WEST SUSSEX COUNTY COUNCIL CONSULTATION

TO:	Arun District Council FAO: Amber Willard
FROM:	Highways, WSCC
DATE:	23/10/2018
LOCATION:	21, North Bersted Street, Bognor Regis, PO22 9AA
SUBJECT:	BE/94/18/HH Dropped kerb to front garden.
DATE OF SITE VISIT:	N/A
RECOMMENDATION:	☒ Advice ☐ Objection ☐ Modification ☐ No Objection ☐ More Information ☐ Refusal
S106 CONTRIBUTION TOTAL:	£N/A

21 North Bersted Street, Bognor Regis, PO22 9AA

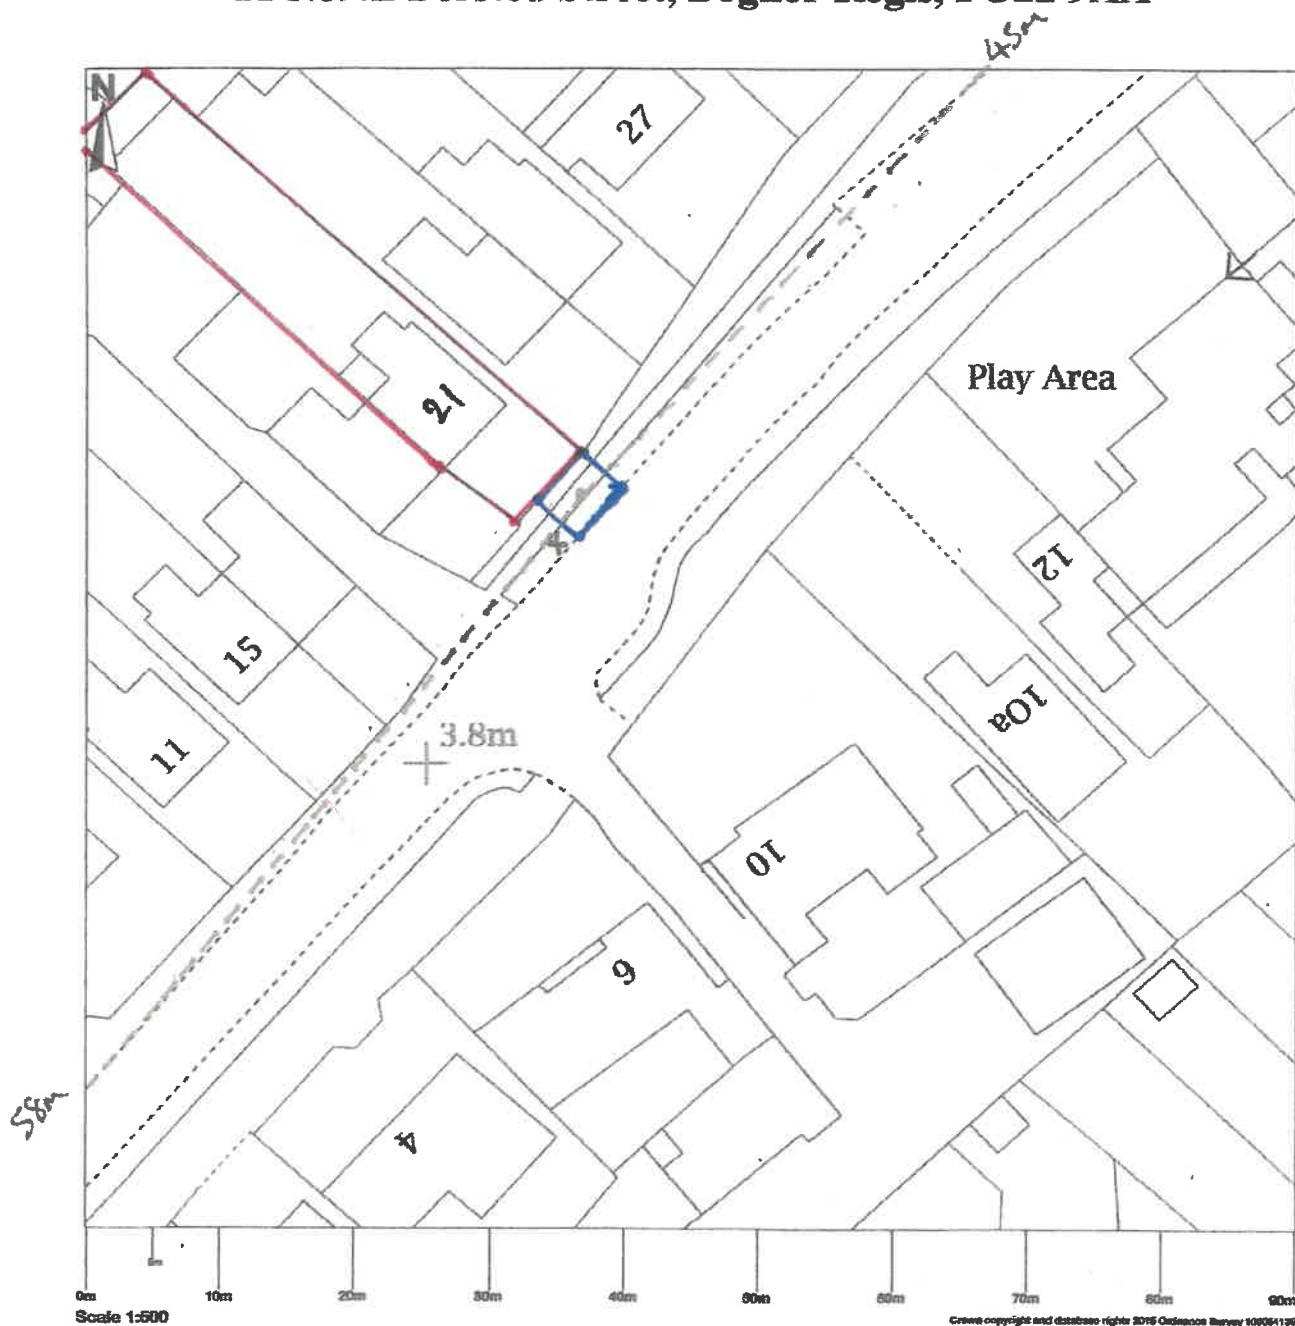
The proposed plans indicate that the proposed VCO will be approximately 4.5m wide. A licence will be required for site access works and the VCO must be constructed to a specification agreed with the Local Highway Engineer.

Vehicular visibility splays have not been demonstrated for the proposed new access onto North Bersted Street. An inspection of WSCC mapping indicates that visibility appears sufficient for the anticipated road speeds and splays are maintainable wholly within the highway boundary. An inspection of data supplied to WSCC by Sussex Police over a period of the past five years reveals that there have been no recorded injury accidents within the vicinity of the site. Therefore there is no evidence to suggest that the existing road network is operating unsafely or that the addition of a VCO would exacerbate an existing safety concern.

The proposed plans do not demonstrate the proposed parking layout for the site. However, there appears to be sufficient space on the site frontage for 2 vehicles to park. A turn on site would be preferred, clearly though there is insufficient space to achieve this. However other properties have similar arrangements and balanced against this is the benefit of providing an opportunity to remove a vehicle that would otherwise be parked on the highway in a location where the existing practice is on-street parking by residents of adjoining properties.

No part of the development shall be first occupied until such time as the vehicular access serving the development has been constructed in accordance with the approved drawing.

No part of the development shall be first occupied until the car parking has been constructed in accordance with the approved site plan. These spaces shall thereafter be retained at all times for their designated purpose.
